Subject: FW: Wappy Springs 2024/92553

From: Ryan Kinder <Ryan.Kinder@kirklees.gov.uk>

I have now received comments back from the Councils section 278 team regarding the design of the site access, as mentioned in comments for the previous application(ref 2023/93031) the site access should be designed in accordance with DMRB standards given the road is subject to a 40 mph speed limit and an abnormal road route. There are a number of other commercial developments on this road which are served by non adopted roads and on site observations indicate these have been constructed in accordance with the forementioned relevant guidance.

KPP Job No	Rev
2278	C
Number	
2013

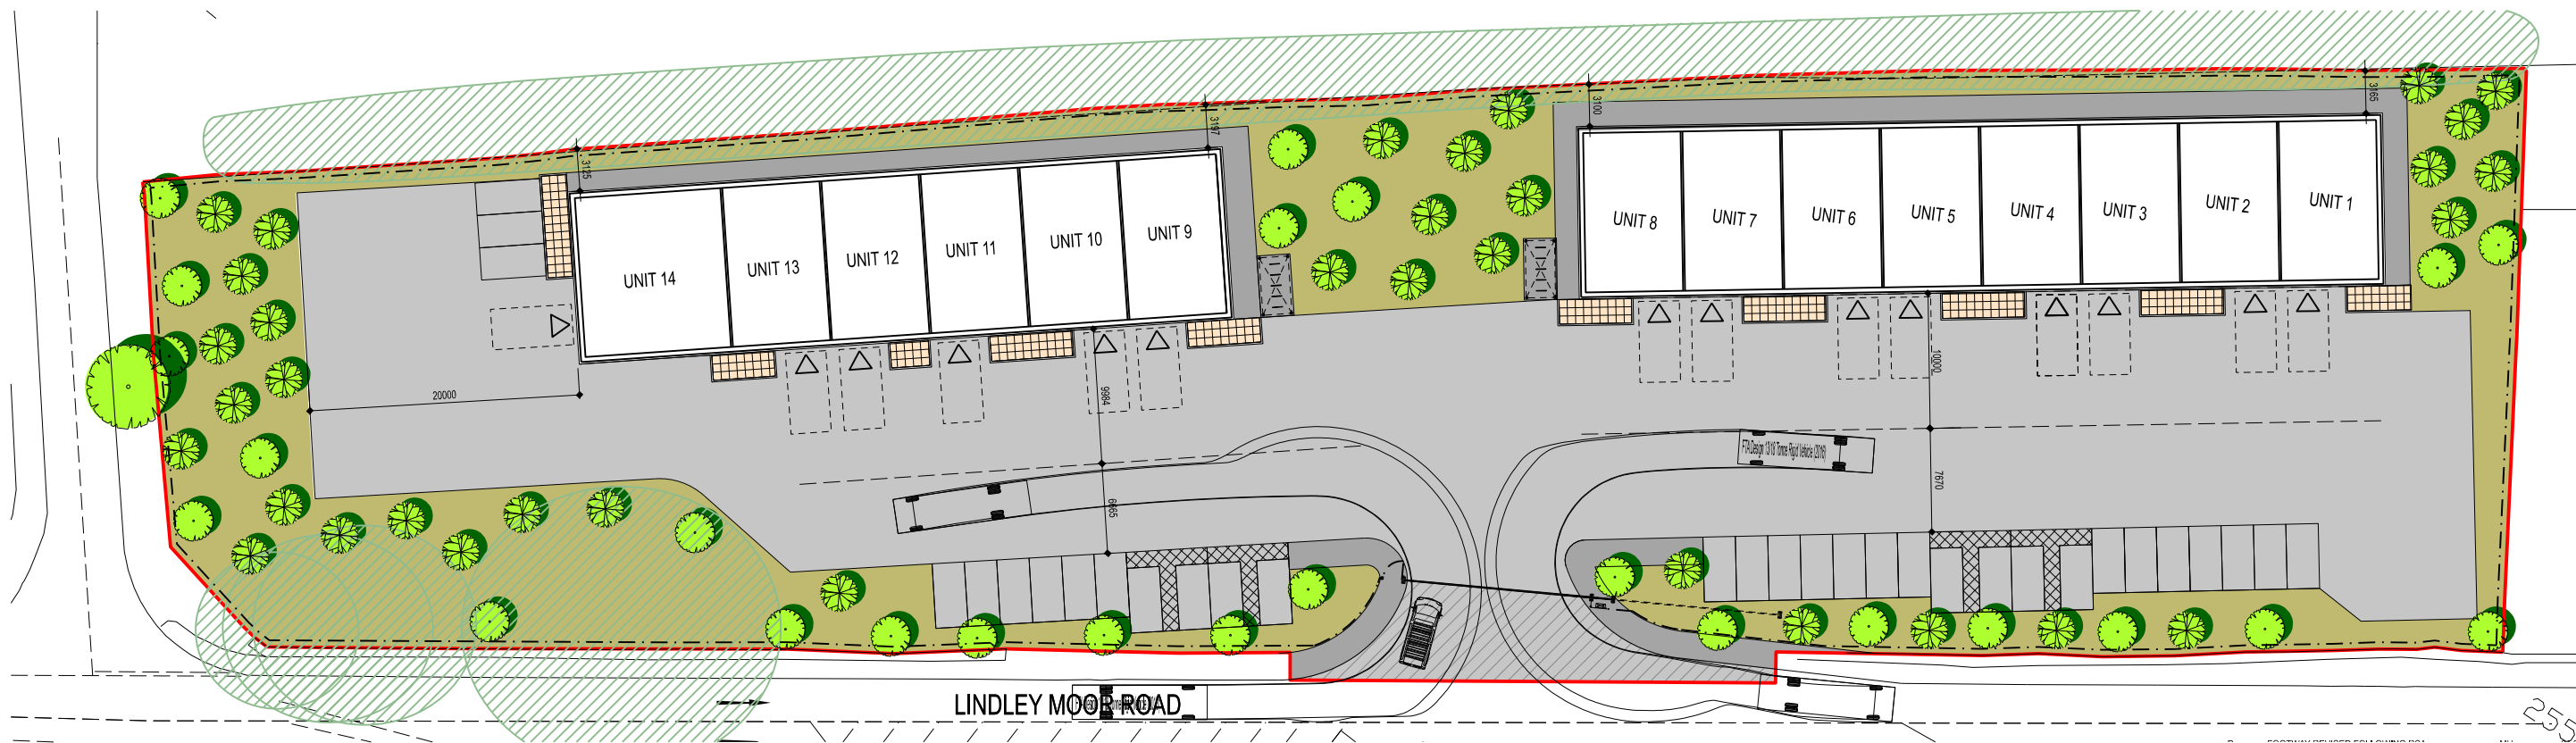
The current design is considered to be substandard for a commercial development and should be redesigned accordingly. The vehicle swept paths indicated are for a refuse collection vehicle of 9.62m in length, this still indicates conflict at the site access and considered unacceptable.

There is still potential for vehicles to overhang the public highway due to the vicinity of the proposed units in terms of vehicular manoeuvres accessing the units.

The proposal in its current form is considered unacceptable from a highways perspective, the design as proposed raises significant highway safety concerns and should be refused on highway safety grounds.
